**KIRKLEES METROPOLITAN COUNCIL
INVESTMENT & REGENERATION SERVICE**

**DELEGATED DECISION TO DETERMINE APPLICATIONS FOR
CONSENT, AGREEMENT OR APPROVAL REQUIRED BY CONDITION**

Reference No:	2025/44/93174/W
Site Address:	Land Adjacent, 2, Hoyle Ing, Linthwaite, Huddersfield, HD7 5RX
Description:	Discharge of details reserved by conditions 7 (boundary treatment), 8 (footway), 10 (bat/bird roosting), 11 (Remediation Strategy), 14 (noise), 15 (CEMP) on previous permission 2022/94124 for erection of 2 dwellings (Use Class C3) and associated landscaping and car parking (within a Conservation Area)
Recommending Officer:	Molly Storer

DECISION – DISCHARGE OF CONDITION – SPLIT DECISION

Figure 2.1 Site measurement positions (Image Source: Google Maps)

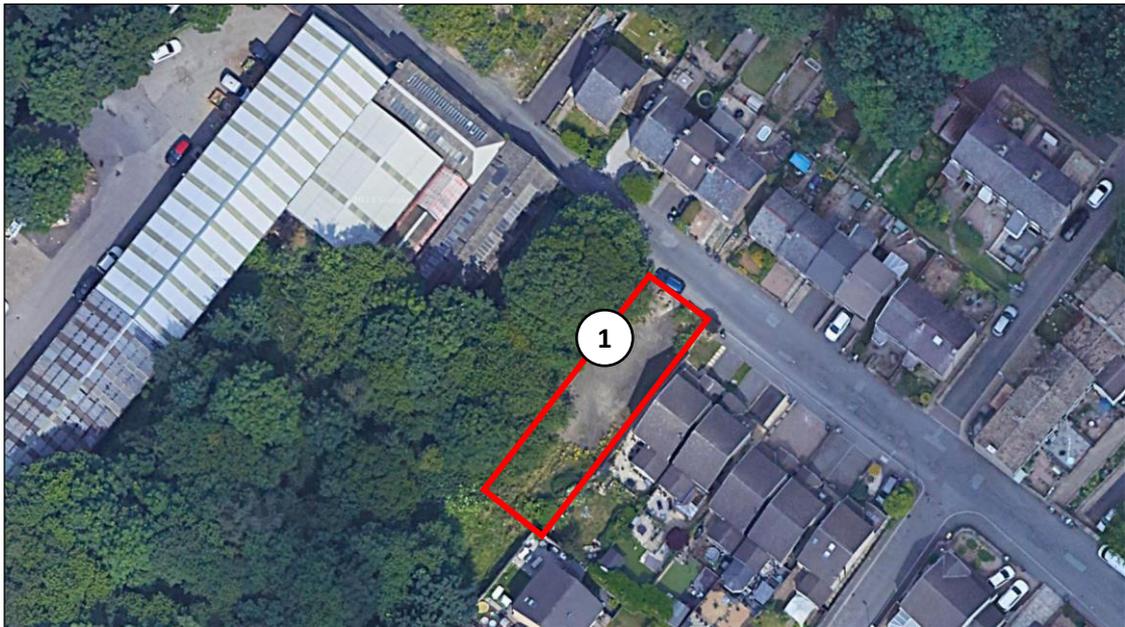
‘The noise survey was undertaken for a 3-hour period, but only “representative” noise levels have been supplied. We would expect more evidence to demonstrate that the presented noise levels are indeed “representative”.

The above noise levels need clarification, along with the provision of all the noise data as evidence of the noise climate on site. Furthermore, the development site is located near to an existing industrial site, the Linthwaite Business Centre. Where several businesses operate, which could result in noise impacting the proposed development.... The submitted noise assessment has failed to demonstrate that the proposed development will not be impacted by noise associated with the nearby Linthwaite Business Centre, and we therefore cannot recommend discharge of condition 14 for noise.’

In light of the responses of the Environmental Health Team condition 14 must remain and cannot be discharged.

Drawing Number: LM25123-DYSE-XX-ZZ-DR-C-1003 Revision: P02

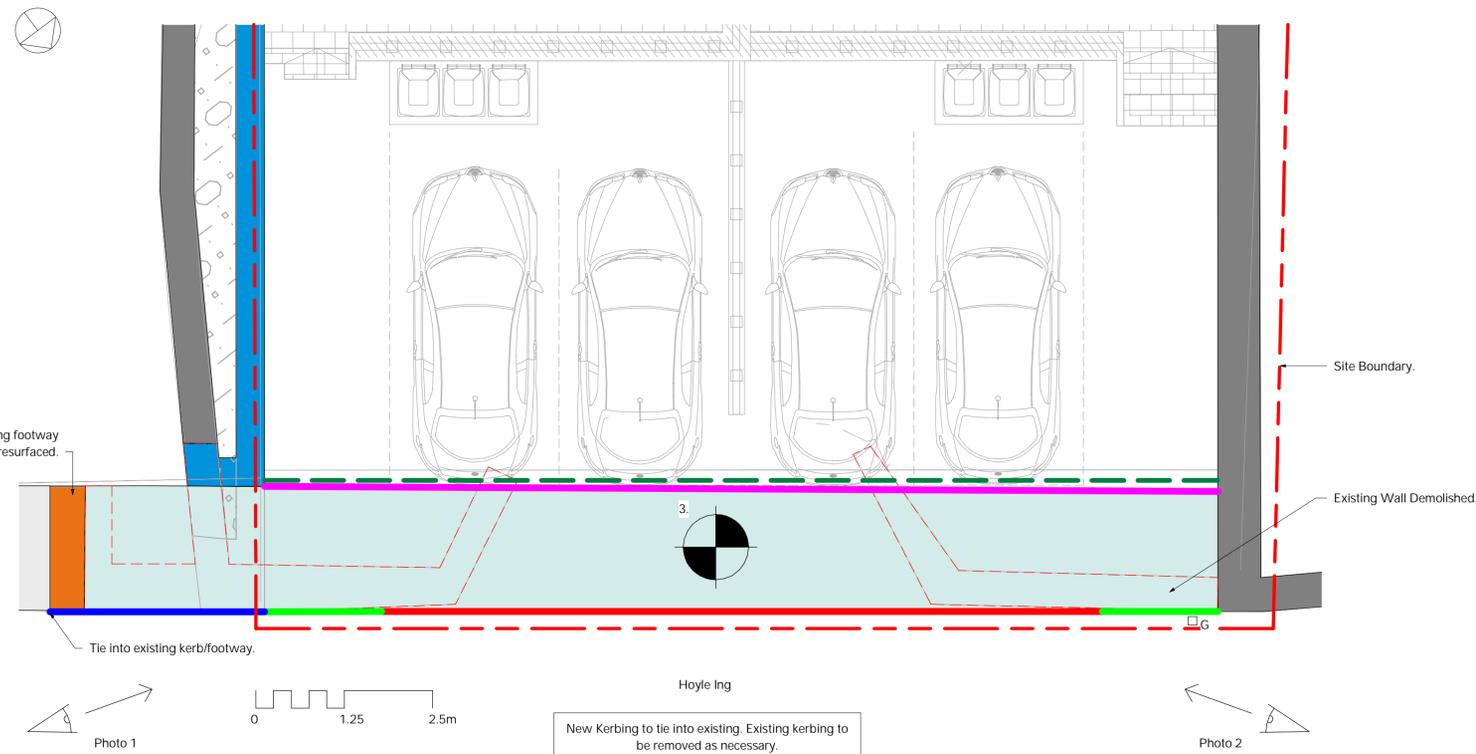
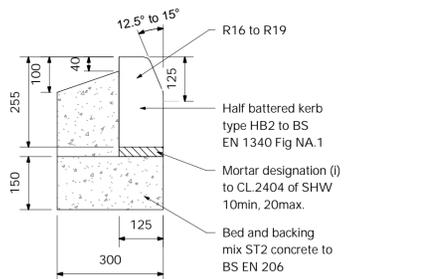
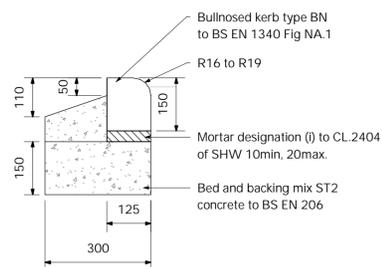
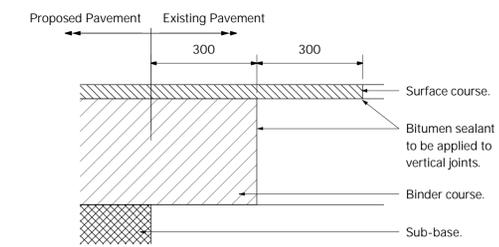
The submitted scheme has been reviewed by the Highways Team, who have stated the information submitted is acceptable in principle and in terms of construction detail is sufficient.

Taking account of the response of the Highways Team it is considered that whilst a separate process would likely need to be undertaken to ensure adoption, for the purposes of discharge of this condition the submitted scheme is suitable.

It is therefore recommended this condition is discharged.

Boundary Treatment Layout

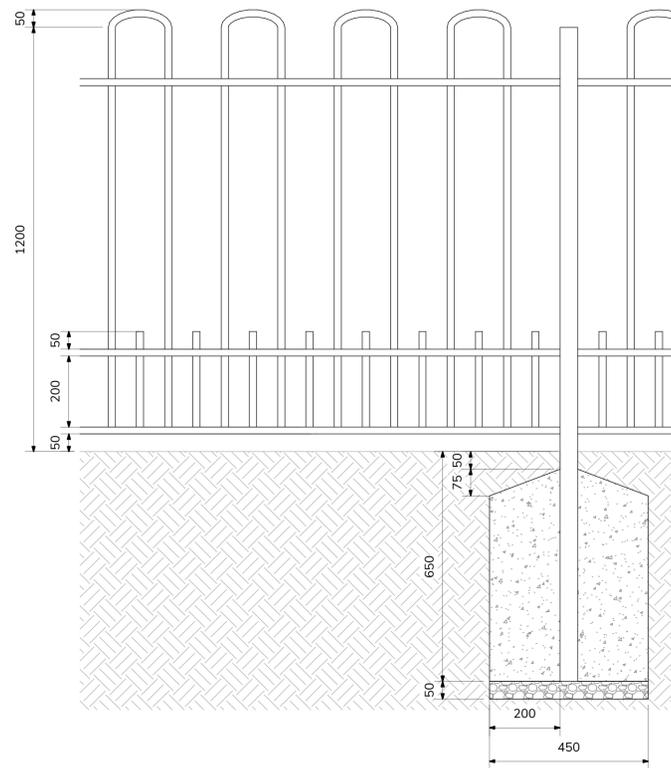
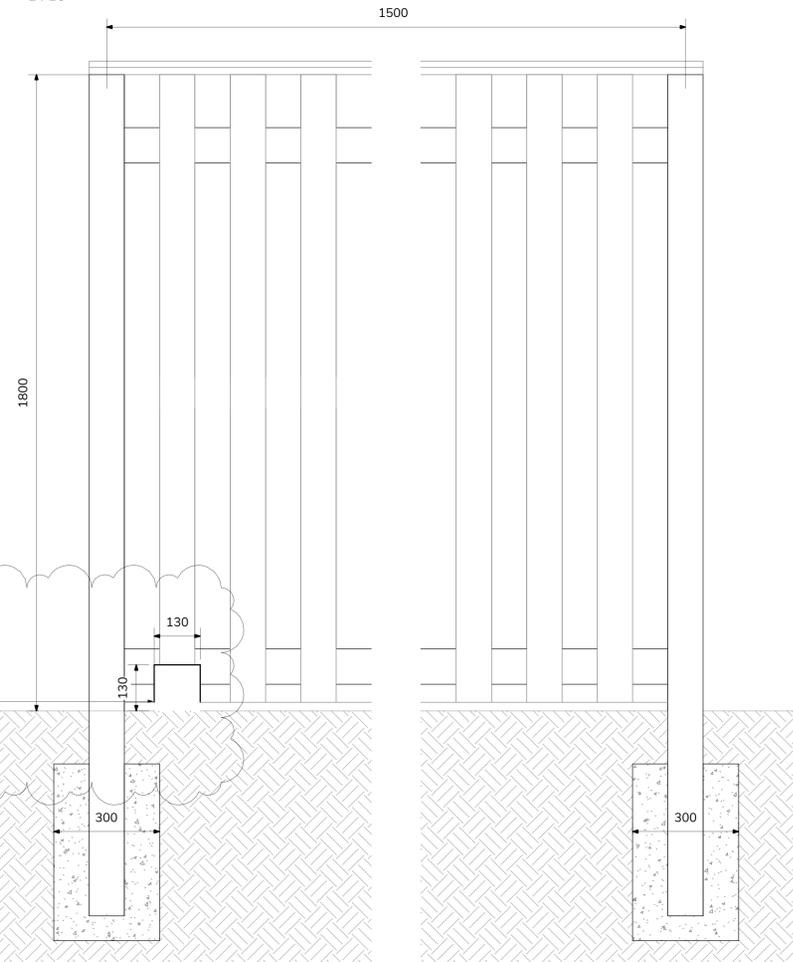
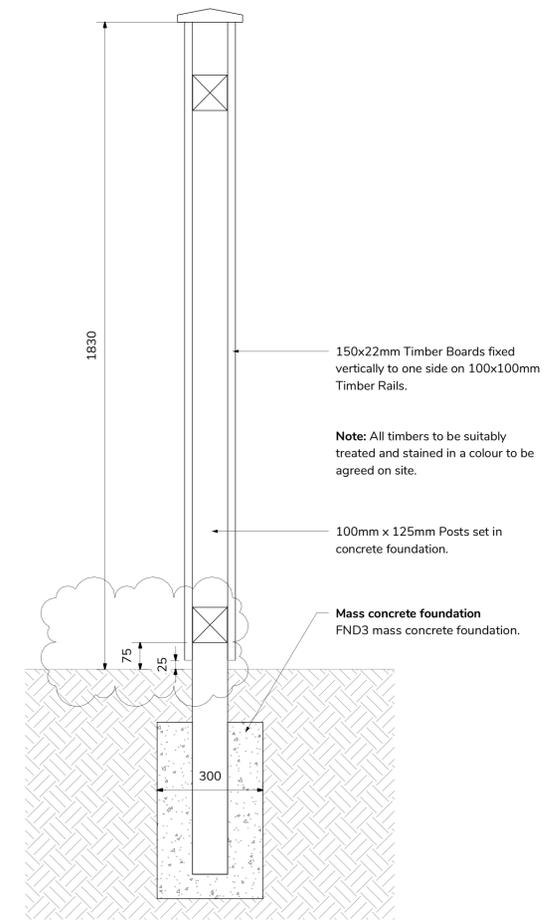
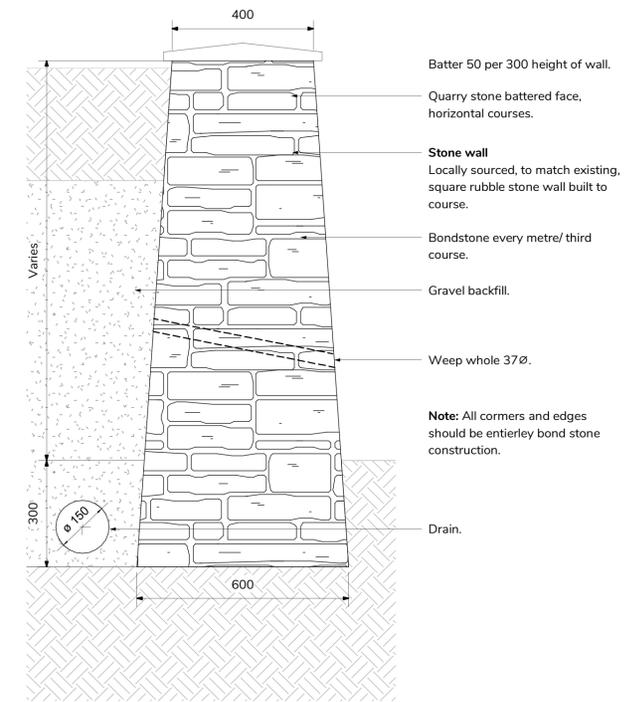
The plan submitted as part of this application shows that there will be a 1.8m high timber fence surrounding the perimeter of the rear gardens (this fence will also be located between the rear gardens). A 1.2m high stone wall will run along the property boundary alongside the properties themselves. This boundary treatment is considered to secure suitable levels of privacy between the future occupiers of the dwellings with regard to private amenity space. The design and materials is considered to be in keeping with that of the boundary treatments for residential properties in the locality and would have an acceptable visual impact.

The boundary treatment plan is therefore considered to satisfy the information requirements of condition 7 and demonstrate an acceptable scheme. It is therefore recommended that this condition be discharged.
